Please ask for: Sian Eggington
Email: sian.eggington@terraquest.co.uk
Telephone: 0121 234 1390
Our Ref: A/263/21/HH
Your Ref:
Date: 20th December 2021

Application for Planning Permission for Works or Extension to a Dwelling

Development: Single storey rear extension.
Location: 3 Ashmead Way Angmering BN16 4AR

Proposed Block 1:500

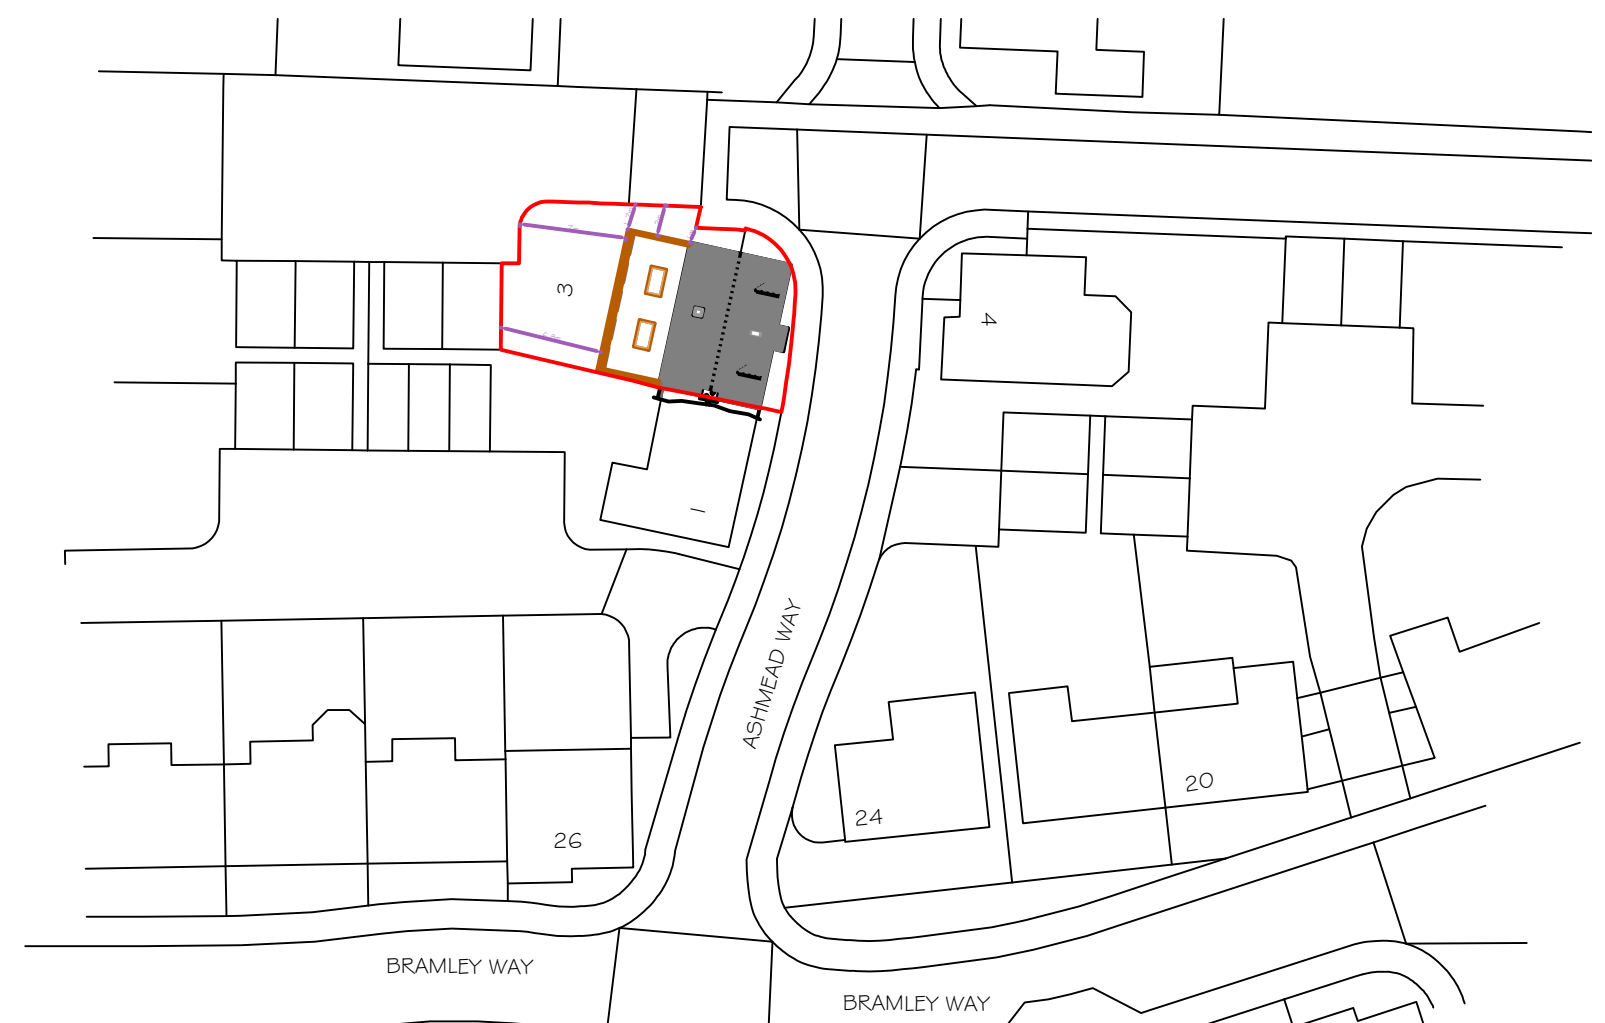
Block Plan: You are required to include dimensions from the proposed extension(s) to all site boundaries. Please amend

Location 1:1250

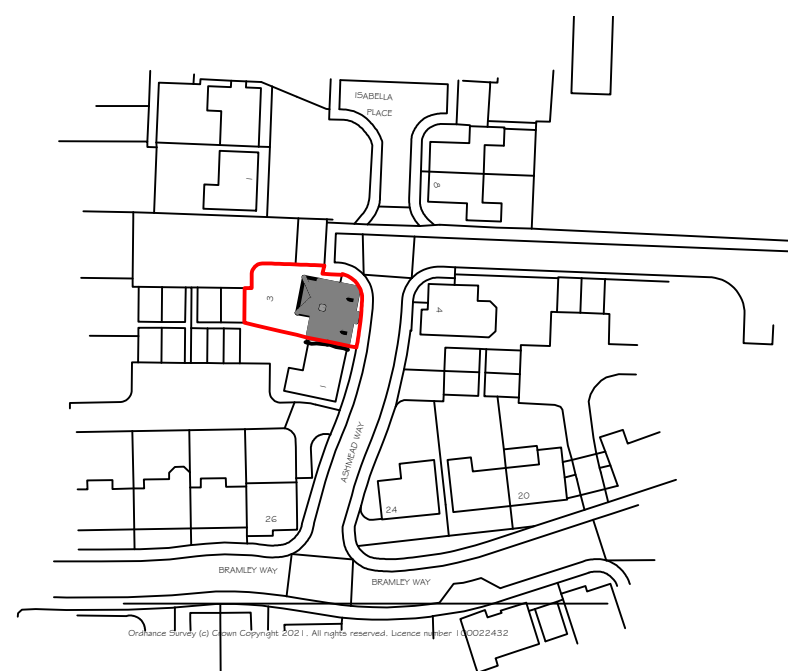
Location Plan: You are required to include a solid red outline on the location plan
